**Hornsby Ku-ring-gai Hospital Redevelopment Stage 2
Palmerston Road, Hornsby (SSD 8647)**

Thank you for your letter dated 13 November 2017 inviting Transport for NSW (TfNSW) to comment on the subject application. Roads and Maritime Services will provide a separate response.

Figure 59 Indicative Construction Traffic Routes

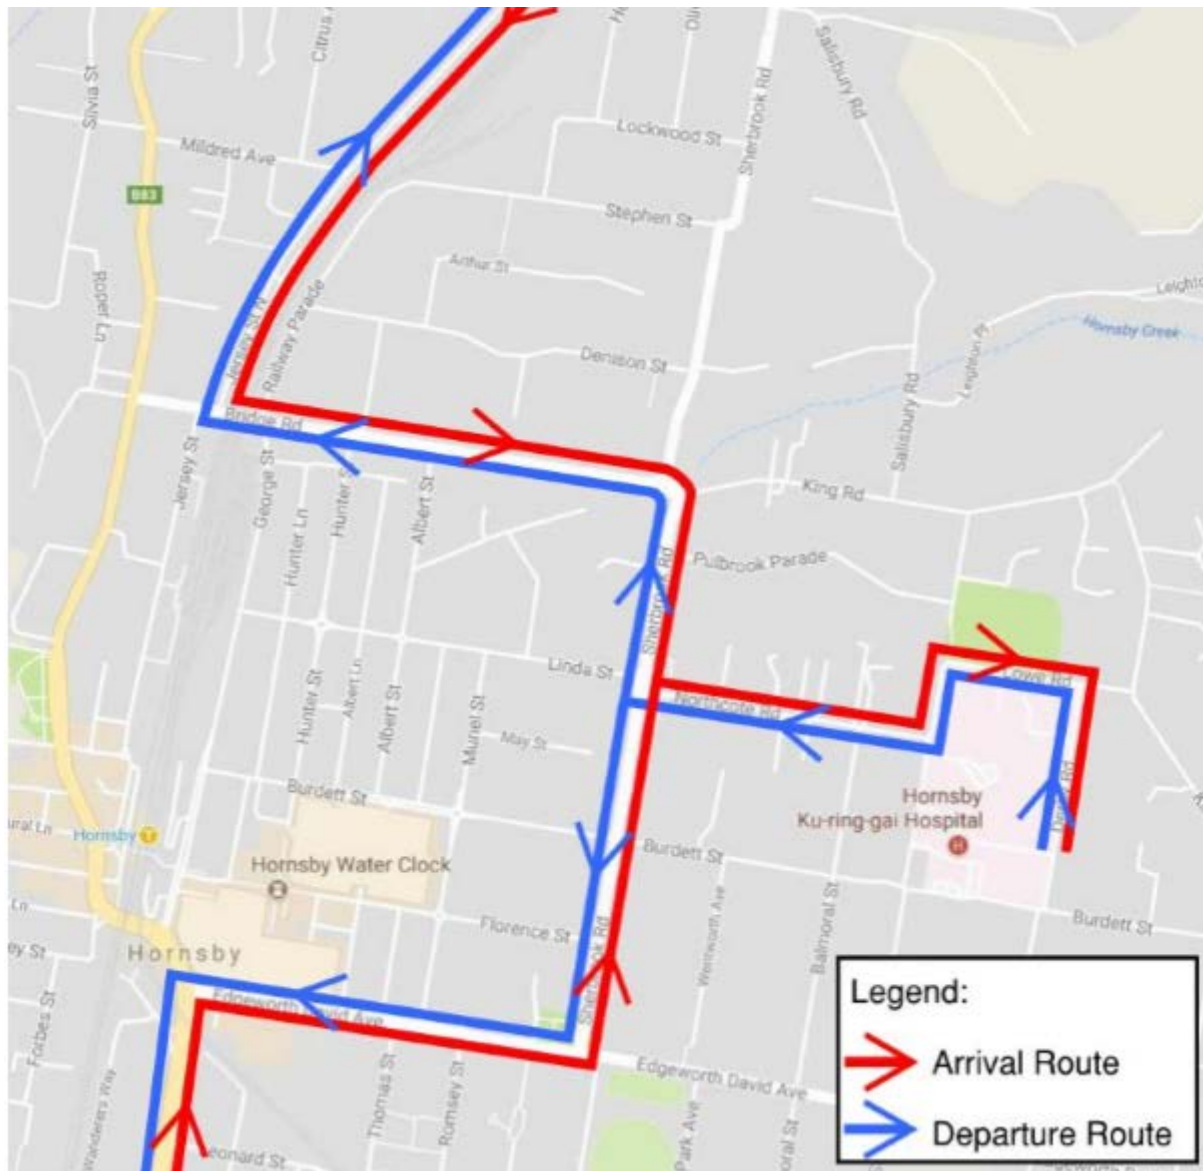
- The Preliminary Construction Traffic Management Plan appreciates the potential hazards and avoids the construction routes from high pedestrian activity at the

nearby medical centre and childcare facilities, and also the school zone near the intersection of Edgeworth David Avenue, Myra Street and Palmerston Road.

- As an alternative, the construction route passes through Lowe Road which runs along the frontage of James Park. It should be noted that James Park is a sportsground site that is used by Hornsby Ku-ring-gai and Hills District Cricket Association and Northern Suburbs Football Association for cricket and soccer for junior and lower grade teams.
- The Preliminary Construction Traffic Management Plan indicates site works will be undertaken on weekdays (7am to 5pm) and Saturdays morning (8am to 12pm) which might potentially coincide with typical weekend sports activities.
- It is requested that the detailed Construction Traffic Management Plan, to be prepared in consultation with Council and submitted for their approval prior to any construction activities on-site, should address the aforementioned matter.

Prior to the commencement of any construction works, a Construction Pedestrian Traffic Management Plan (CPTMP) shall be prepared in consultation and approved by Council and submitted to the satisfaction of the Certifying Authority. The CPTMP must specify, but not be limited to, the following:
